WELWYN HATFIELD BOROUGH COUNCIL – DEVELOPMENT MANAGEMENT
DELEGATED REPORT

APPLICATION No:	S6/2013/916/FP
APPLICATION Site:	Oshwal Centre, Coppers Lane Road

The application seeks full planning permission for a two storey side extension which in-fills an existing recessed section on the east wall. At the lower ground level this will provide an extension to the lower hall and provide an improved access to an existing external patio area. At the upper level the new floorspace will provide storage space which will serve the main hall area.

EXISTING AND PROPOSED PLANS - ELEVATIONS

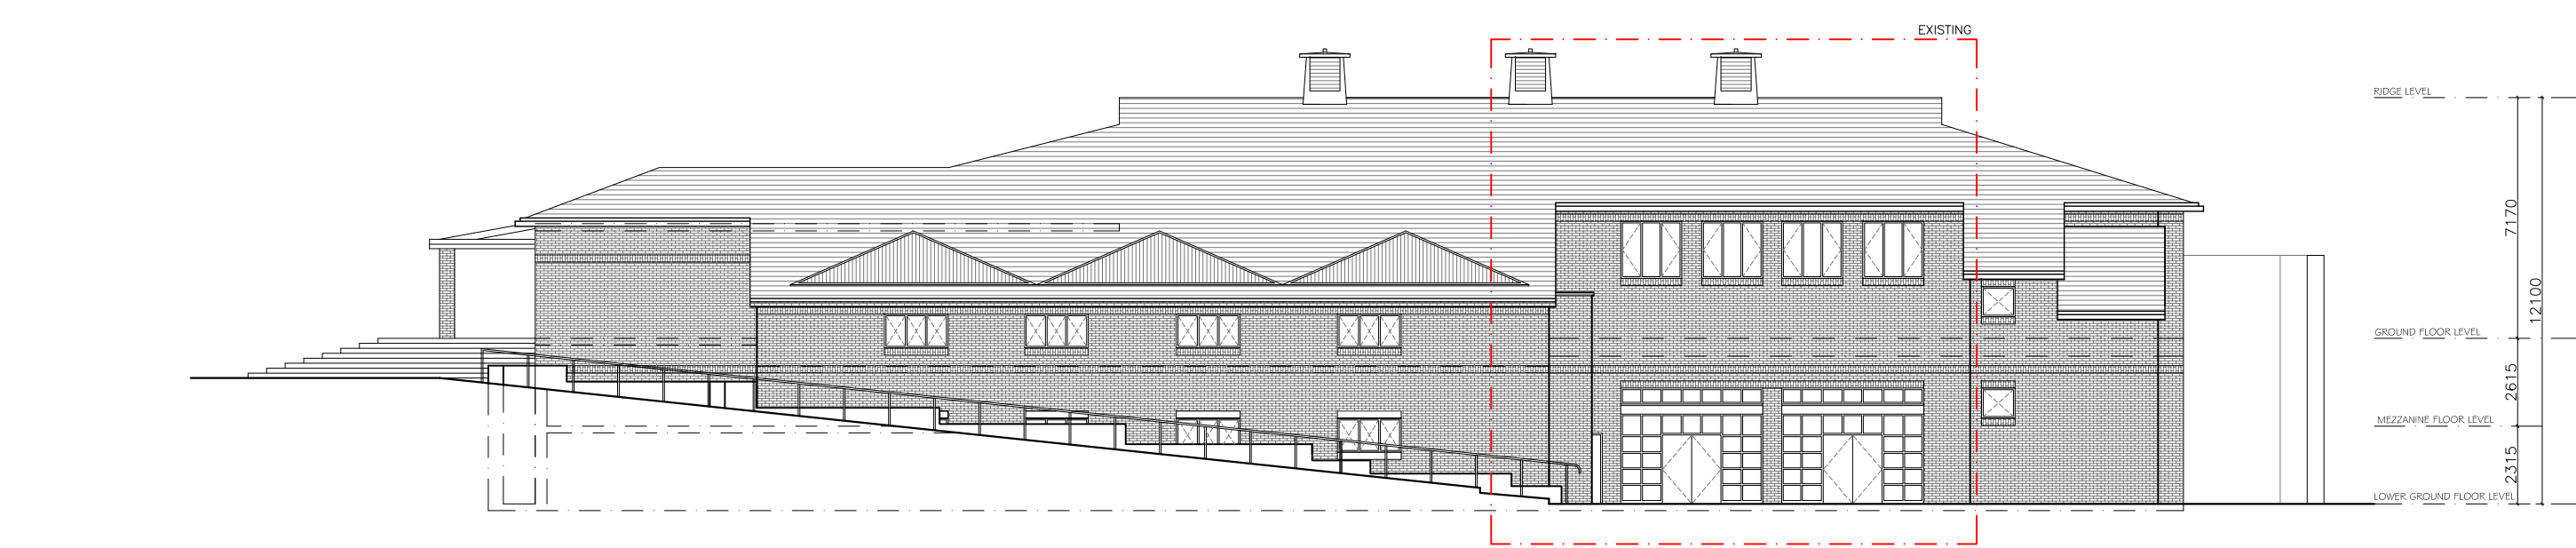
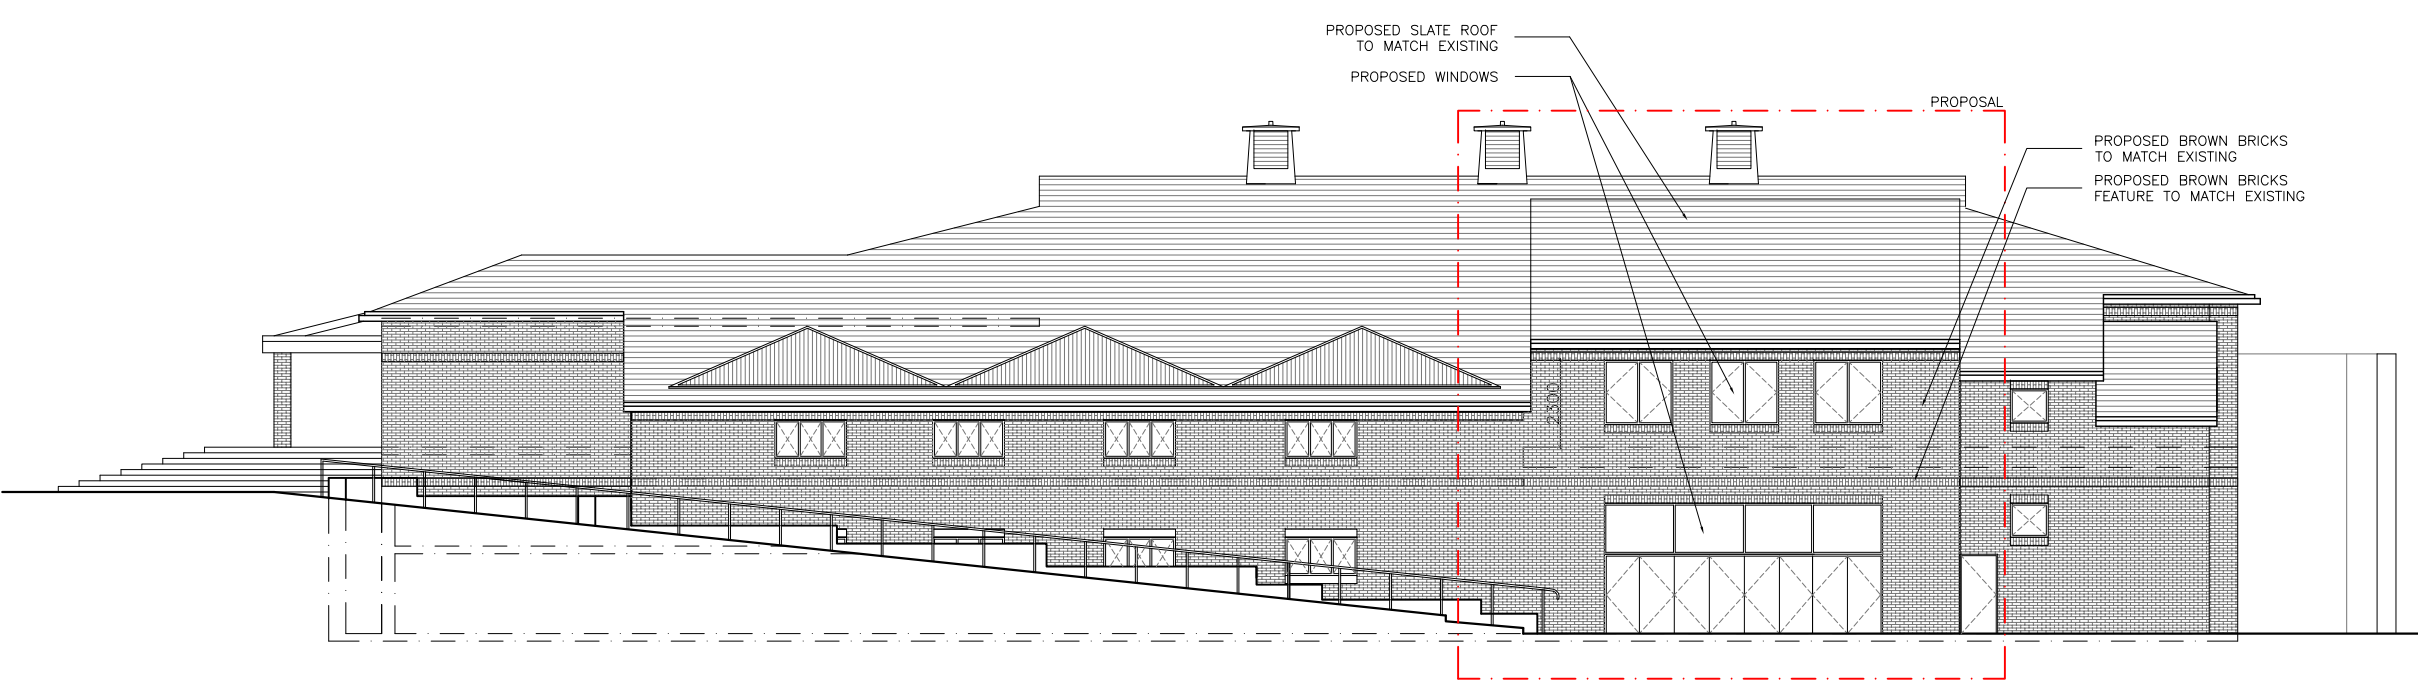
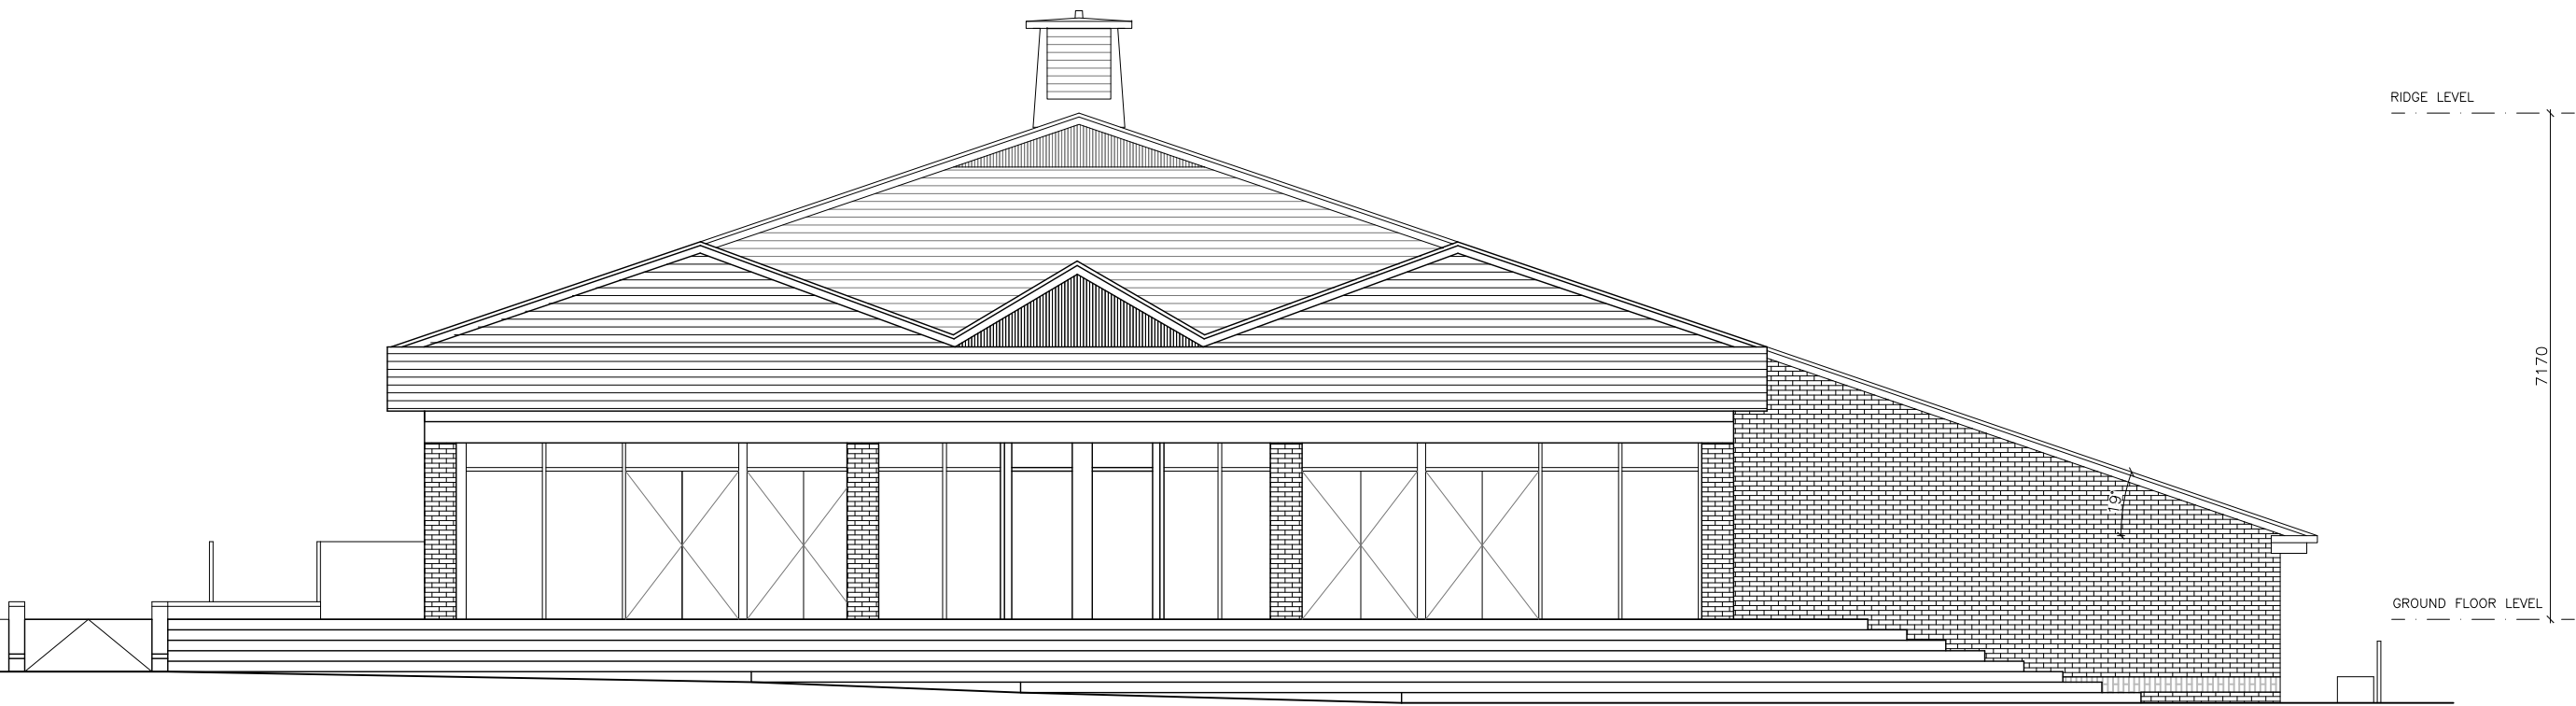
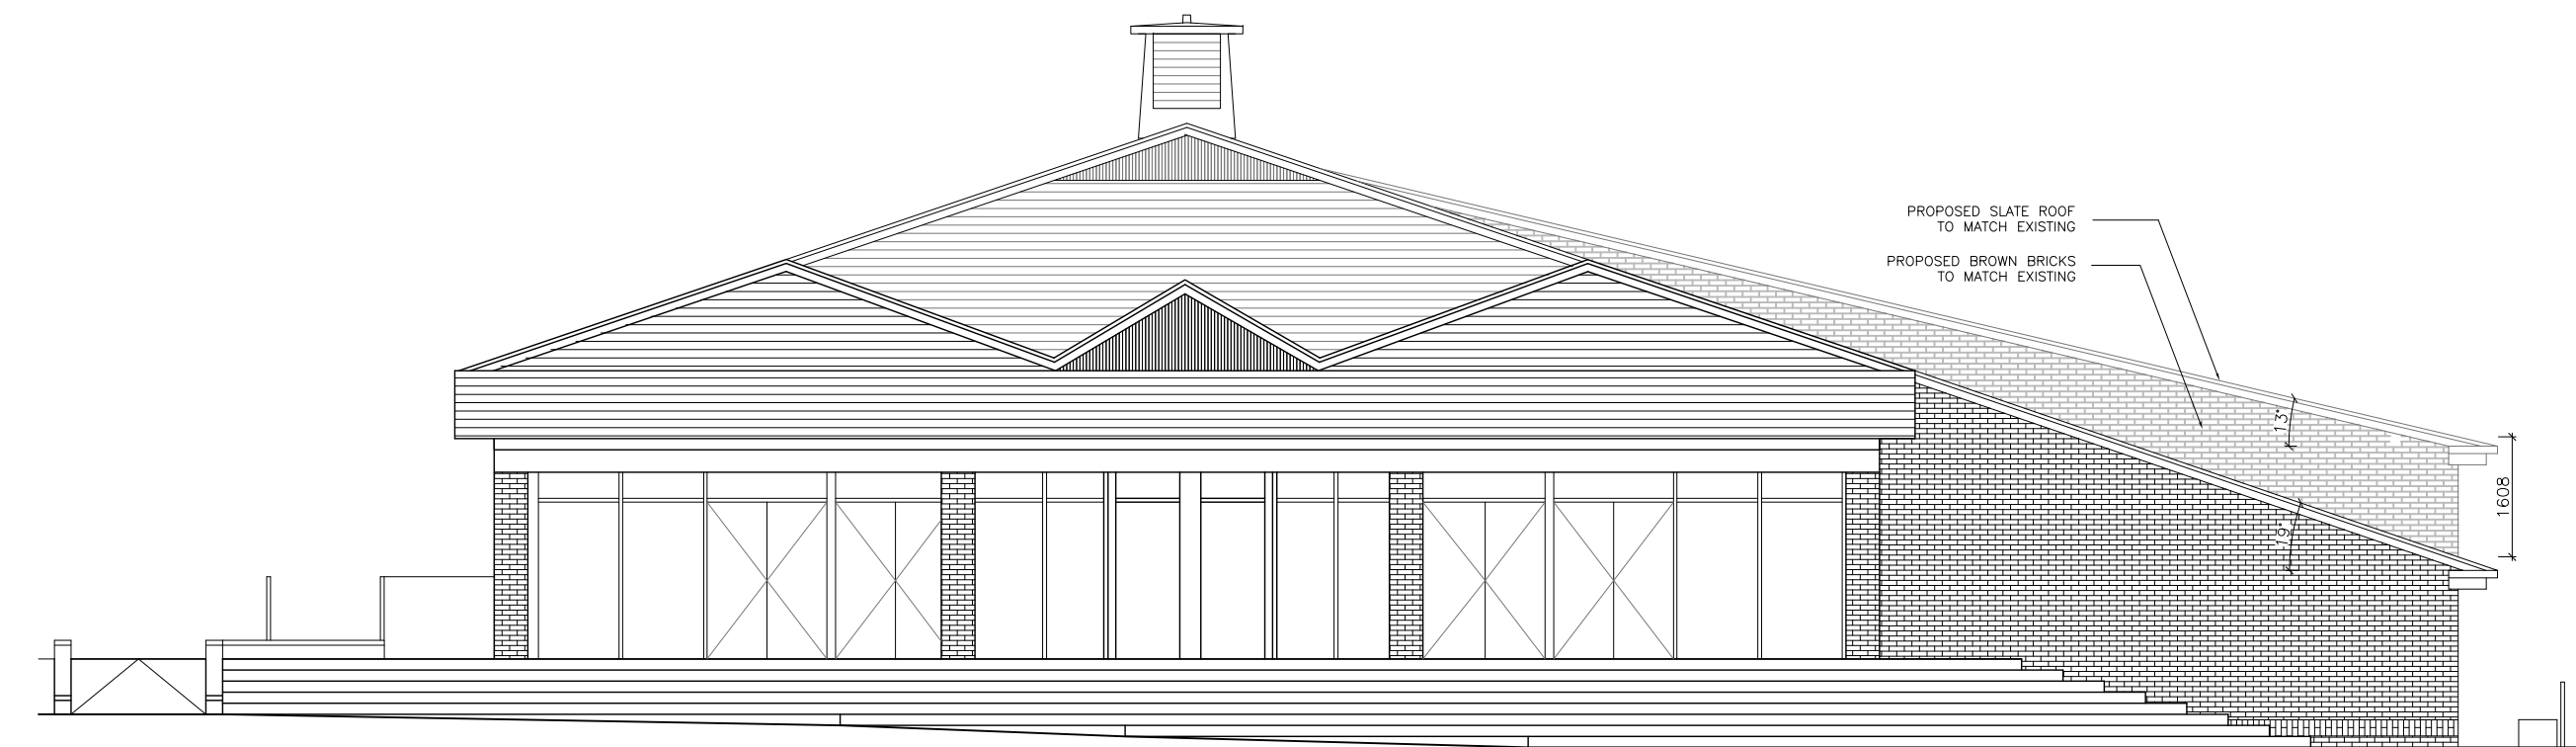
The fenestration at the upper floor level will change as three windows will replace the existing four windows. The proposed materials for the walls and roof are to match the existing and the windows are to be double glazed to improve the thermal and sound attenuation performance.

The new roof will be raised at the eaves levels by approximately 1.6m to provide sufficient headroom.

The design of the new extension will infill an existing recessed section of the east wall and will be in keeping with the wider character of the original building.

The use of matching materials would be the most appropriate approach in this development as indicated by the application drawings.

With regard to design, it is considered that the proposed development would be of a good quality which would meet the design requirements of Local Plan D1 and D2 and the accompanying Supplementary Design standards subject to a planning condition requiring the use of matching materials.
